From: [REDACTED]
To: [Planning Comments \(Shared Mailbox\); Lizzie Mugova](#)
Cc: [REDACTED]
Subject: RE: Comments to Planning Application: 6/2023/1442/PN27 - 41 Northaw Road East
Date: 30 July 2023 21:50:07

Re: Application Reference: 6/2023/1442/PN27
Proposed Development at: Freny Cottage 41 Northaw Road East, Cuffley, Potters Bar EN6 4LU (the “**Application**”)

Proposal existing and proposed layouts

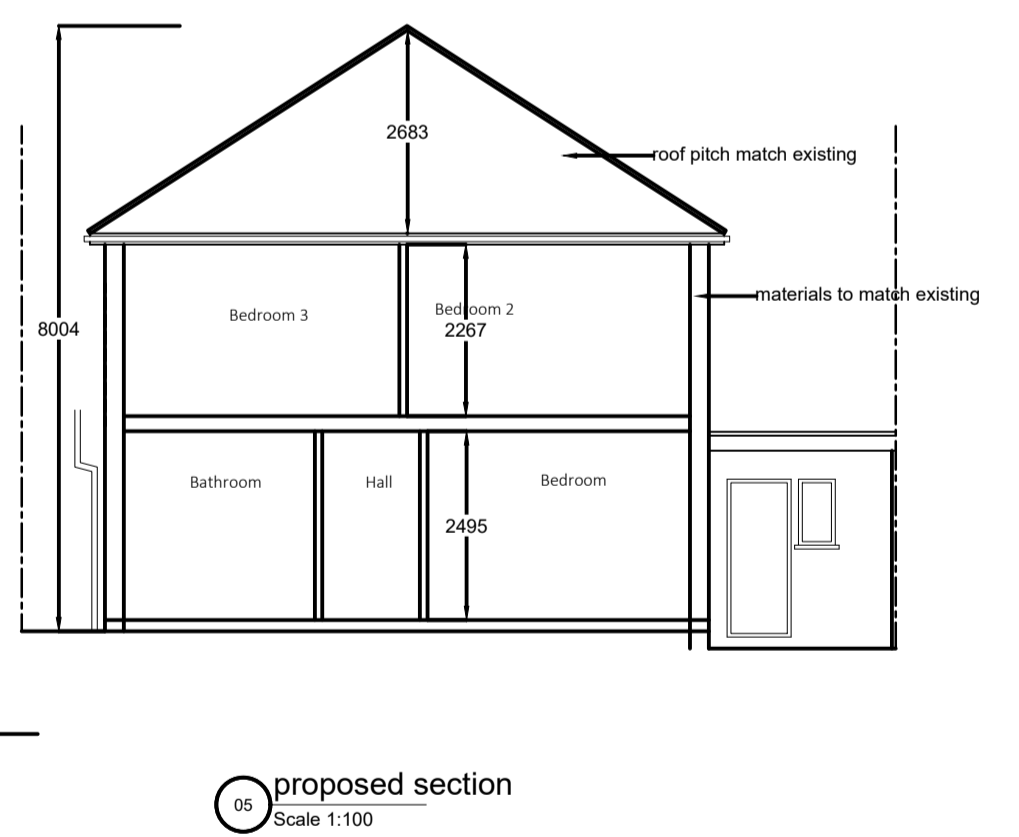
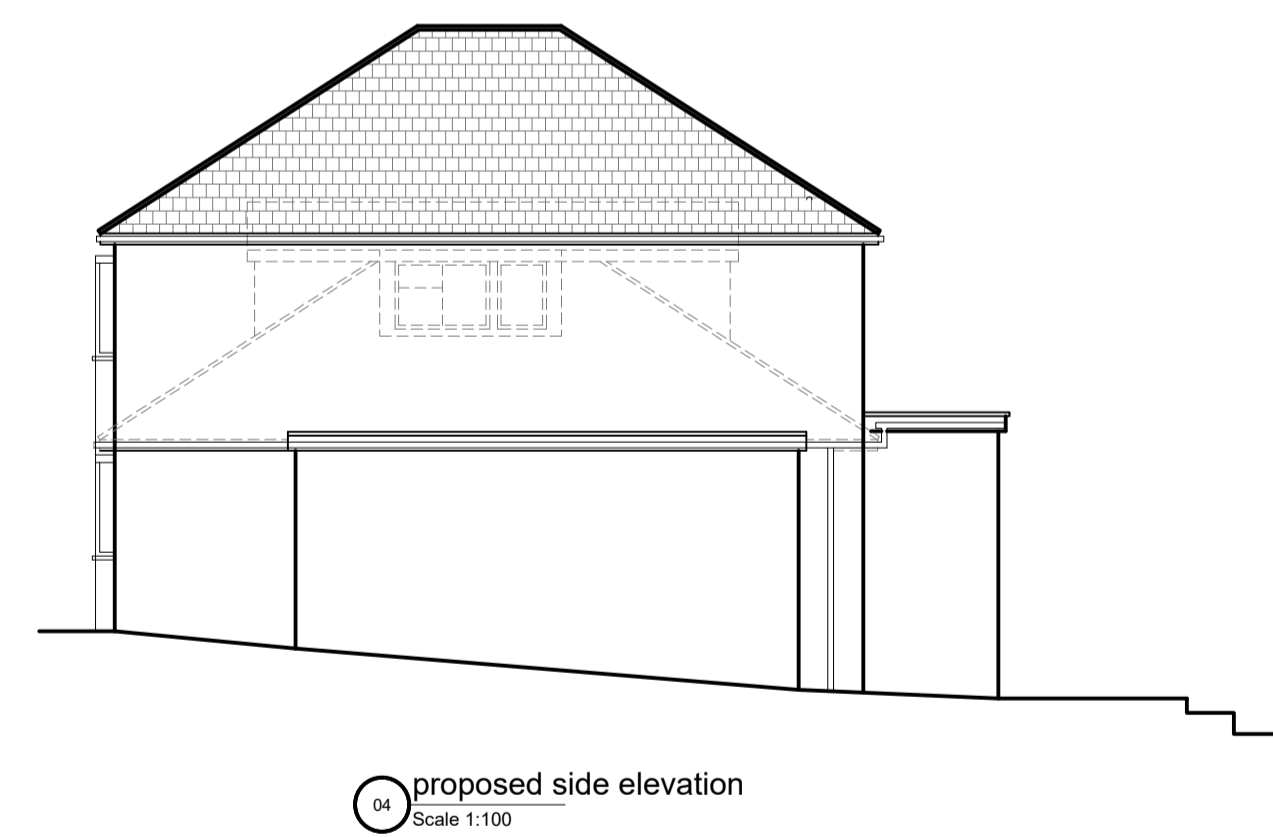
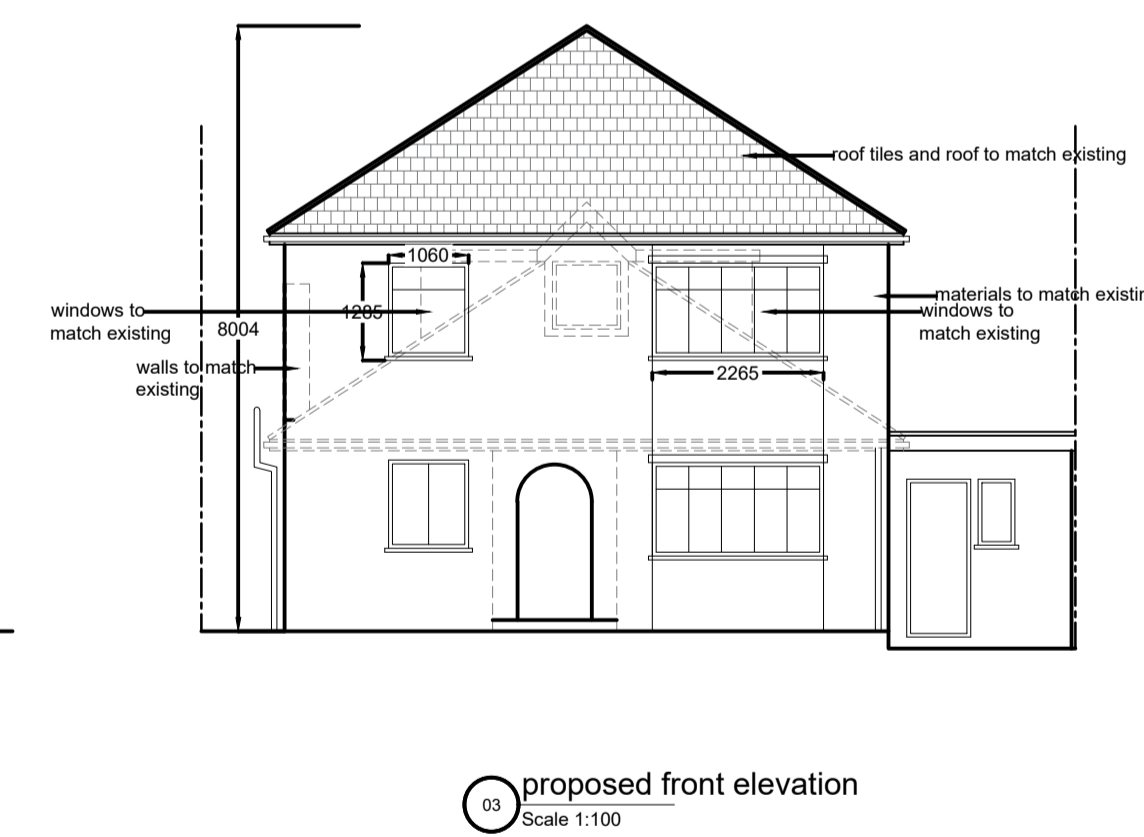
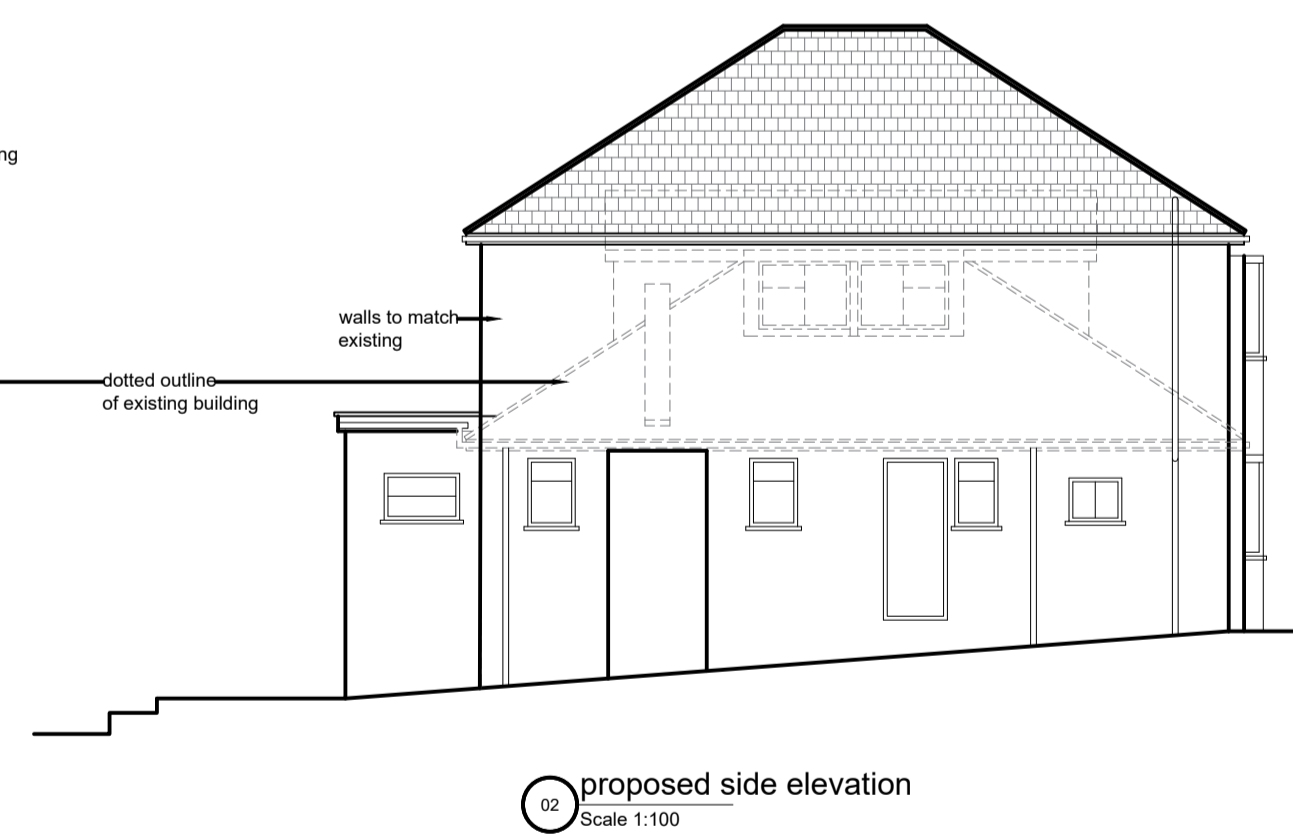
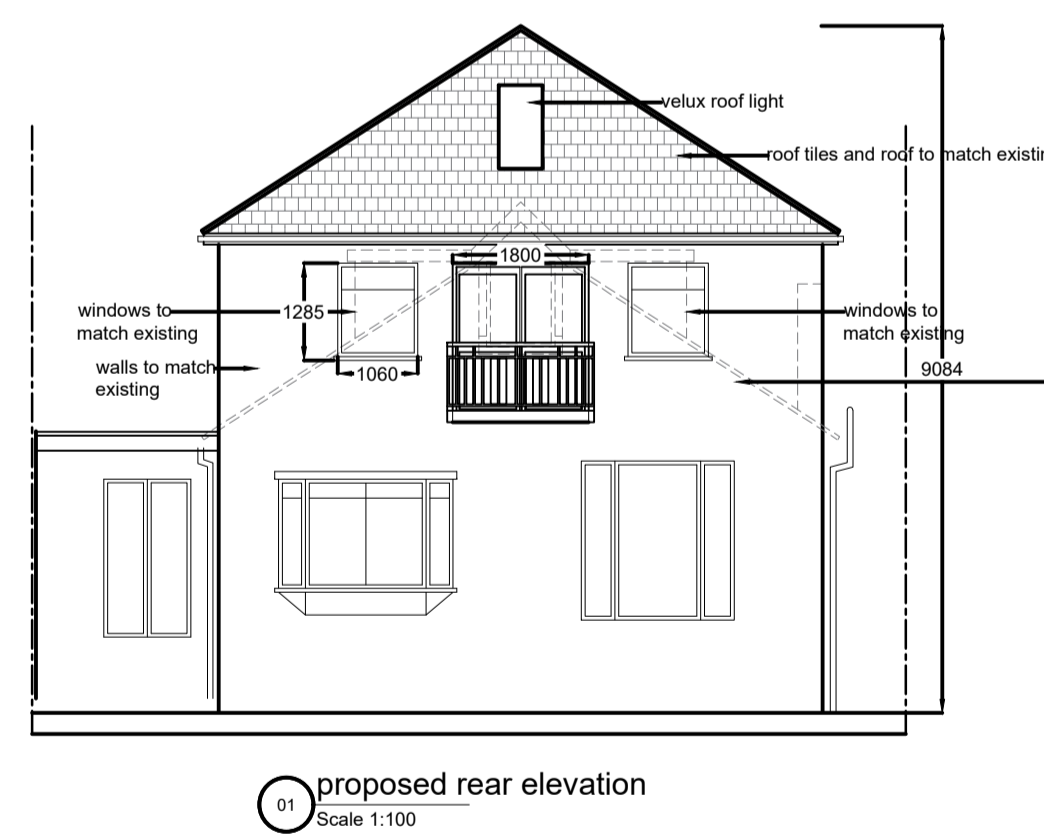
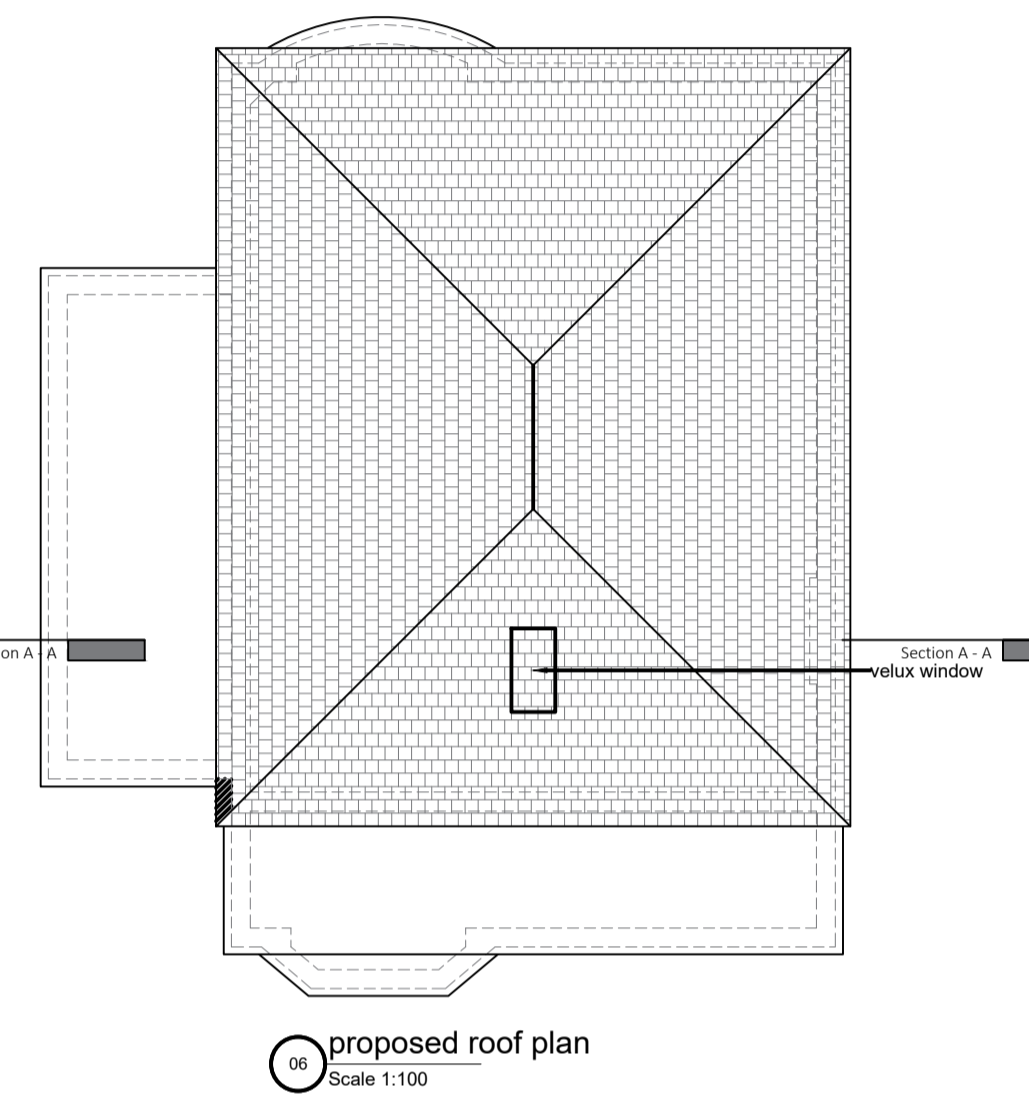
- The proposed development is incongruous with the local area, a two-storey house amongst 1930s chalet bungalows;
- The ridge height would render it a sore thumb, it would not blend at all with nearby housing;
- We do not believe that the application is in accordance with Permitted Development rights;
- We are concerned by safety and nuisance aspects relating to the Construction Management Plan; and
- We do not believe that the application is in accordance with the Cuffley Neighbourhood Plan.

We believe that the ridge height proposed entirely contravenes D1(e).

We note that the current Application does not have many windows. Unfortunately, the works to No.45 had a tendency for scope creep from the original plan to the finished design – as clearly evidenced by the applications and numerous Parish Council decisions. Given the lack of windows shown on the current Application, we believe that such scope creep is likely to occur again. We envisage that there is already an intention for additional windows not stated on the current Application.

We request that the Council please specify that no side-elevation windows will be permitted on this development.
